**SSD 6626 - SICEEP Darling Square - Mixed Use
Residential Building within North-East Plot**

**Submission
OBJECTION**

21 November 2014

Concept proposal
parameter plan shadows
for N + SE plots

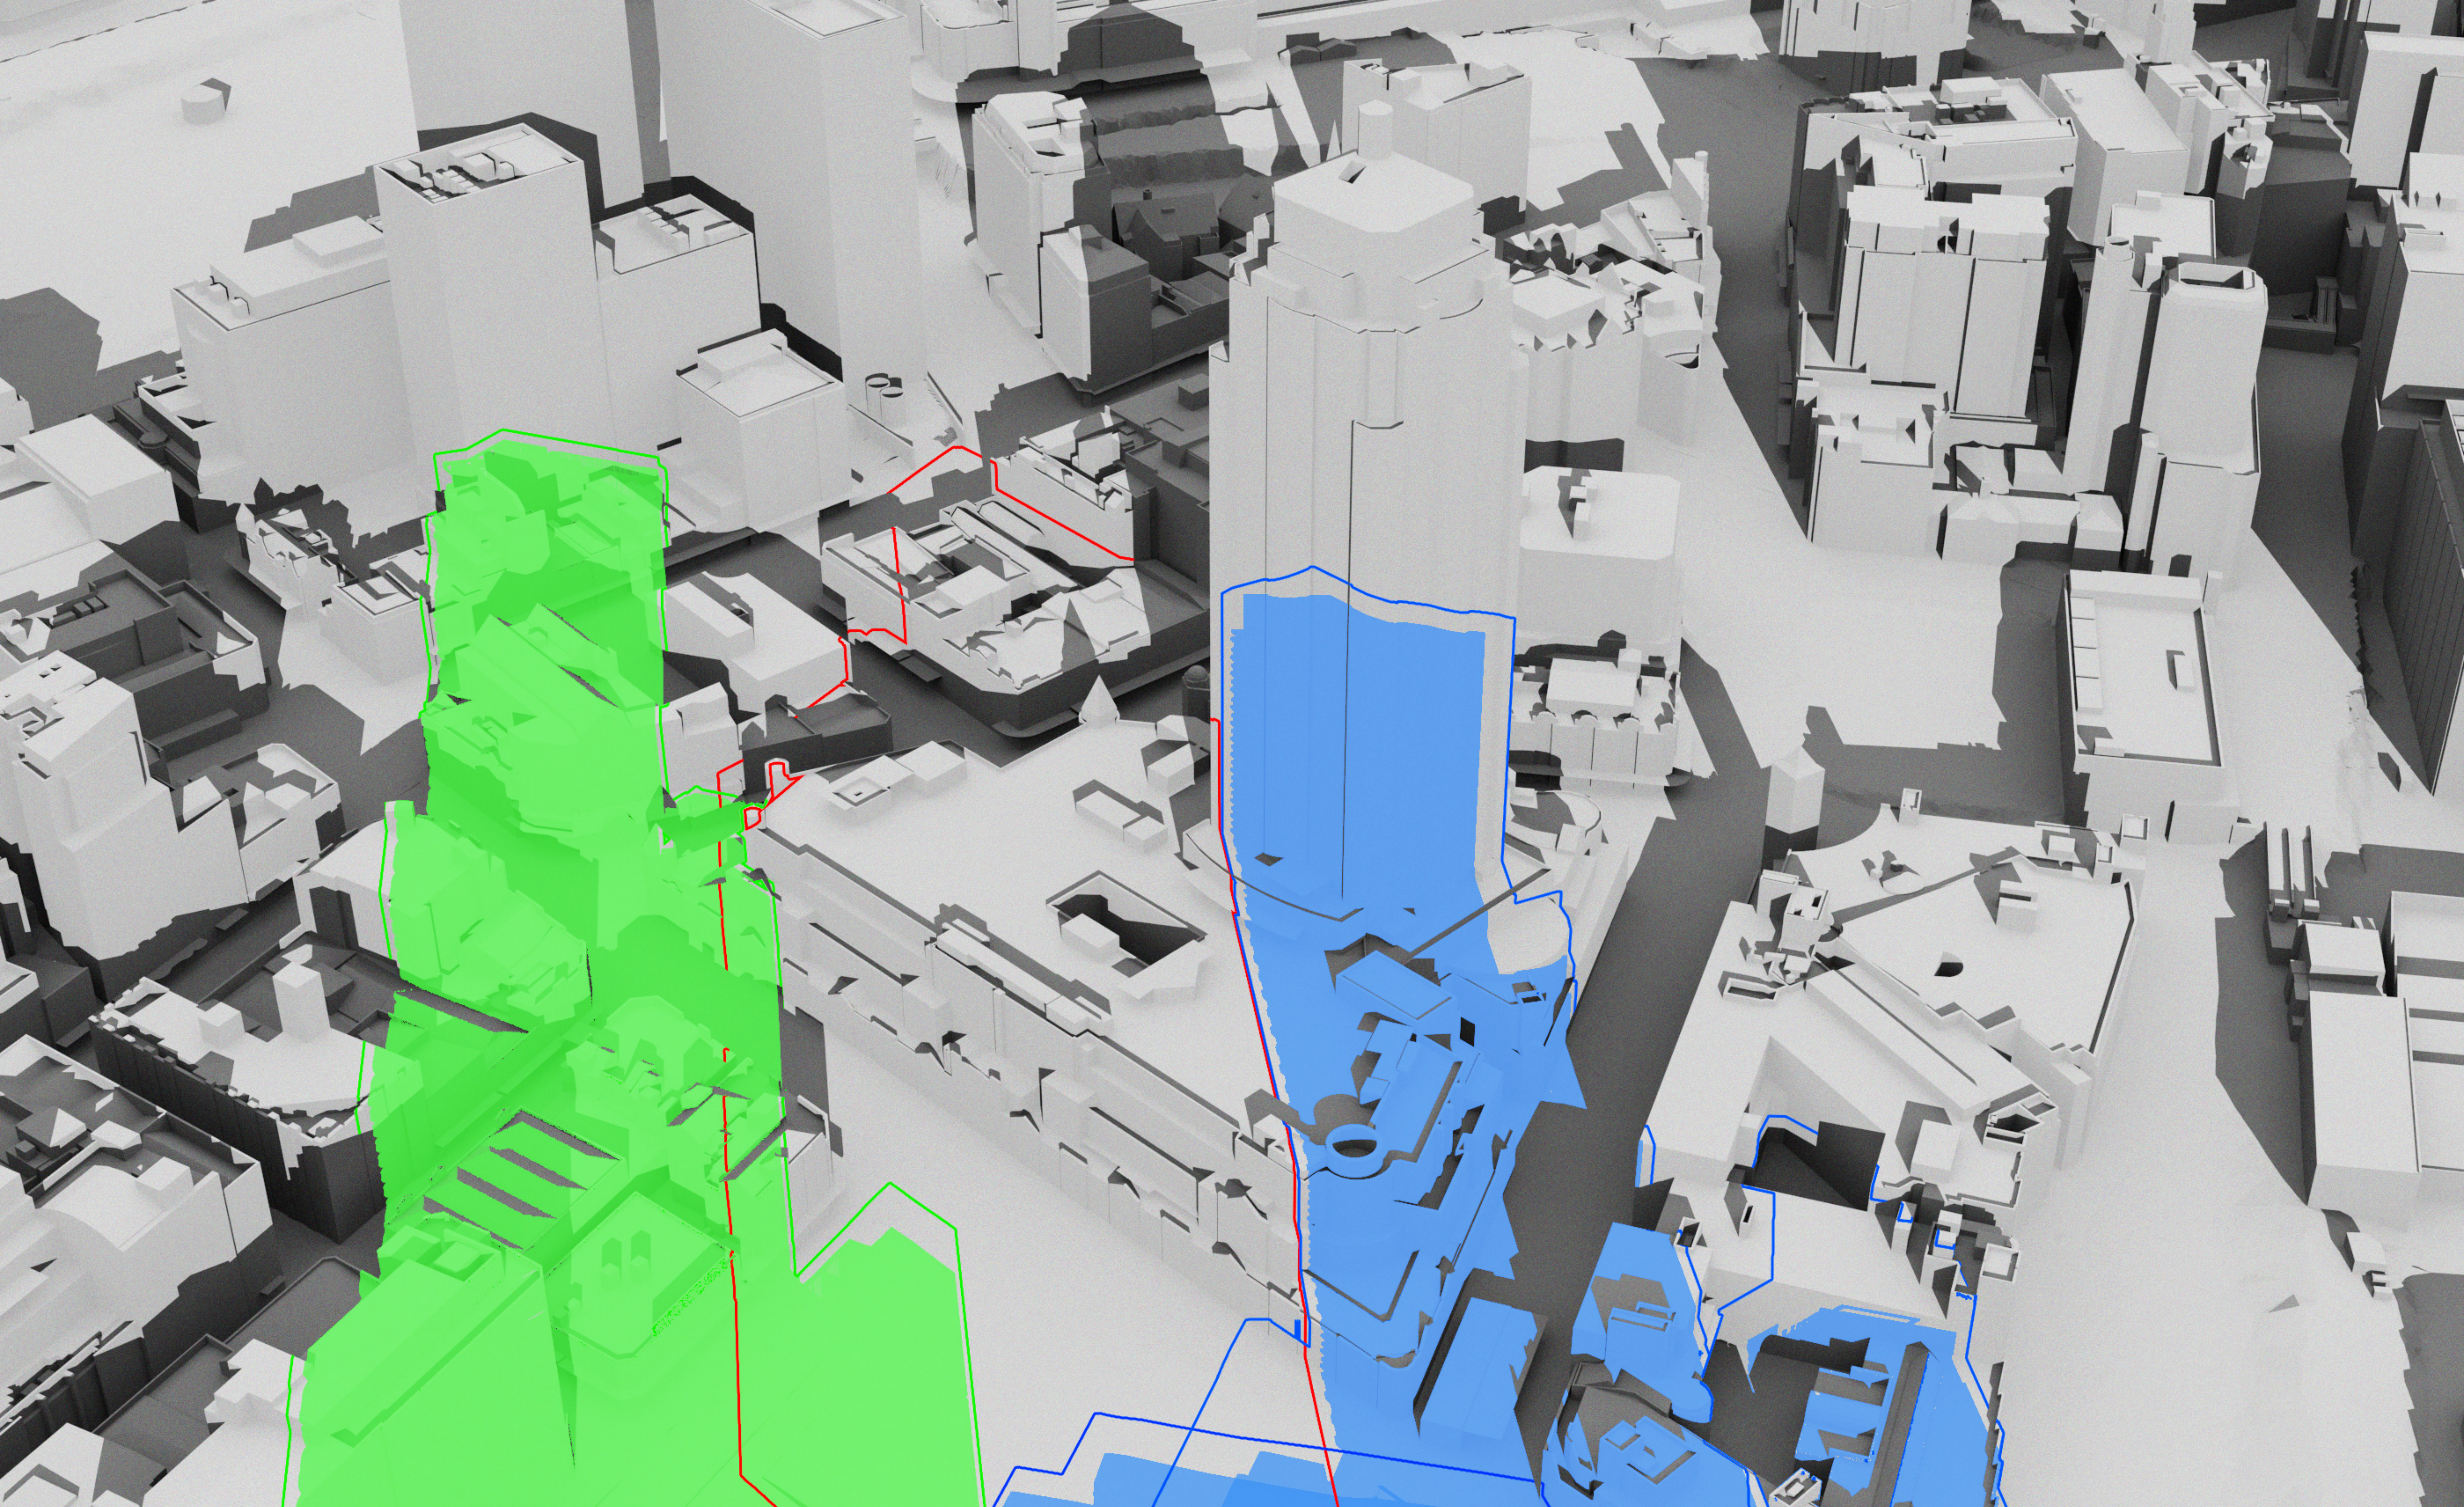
With respect to the podium of The Peak Apartments, the EIS states that " The landscaped podium associated with The Peak Apartments will continue to receive at least two hours of solar access, ensuring compliance with the intent of the Sydney DCP 2012.". Although this statement is true, two hours is a major reduction from the existing 21 June daylight access of about six hours.

Excessive overshadowing of The Peak apartments

There is no overshadowing of apartments in The Peak by the NE plot. The overshadowing is by the SW plot being developed by the same proponent.

Excessive overshadowing of public open space - the new square - "Haymarket Square"

We agree with the City of Sydney's view that "excessive morning shadows are cast into the outdoor and café areas in the new square by new surrounding building edges. In order to improve morning sun access to the square in winter, it is recommended that the building heights lining the new square be reduced and the floor area relocated to the surrounding streets podium edges..." Source: City of Sydney, SSD 5878 (SICEEP) The Haymarket submission, page 34.
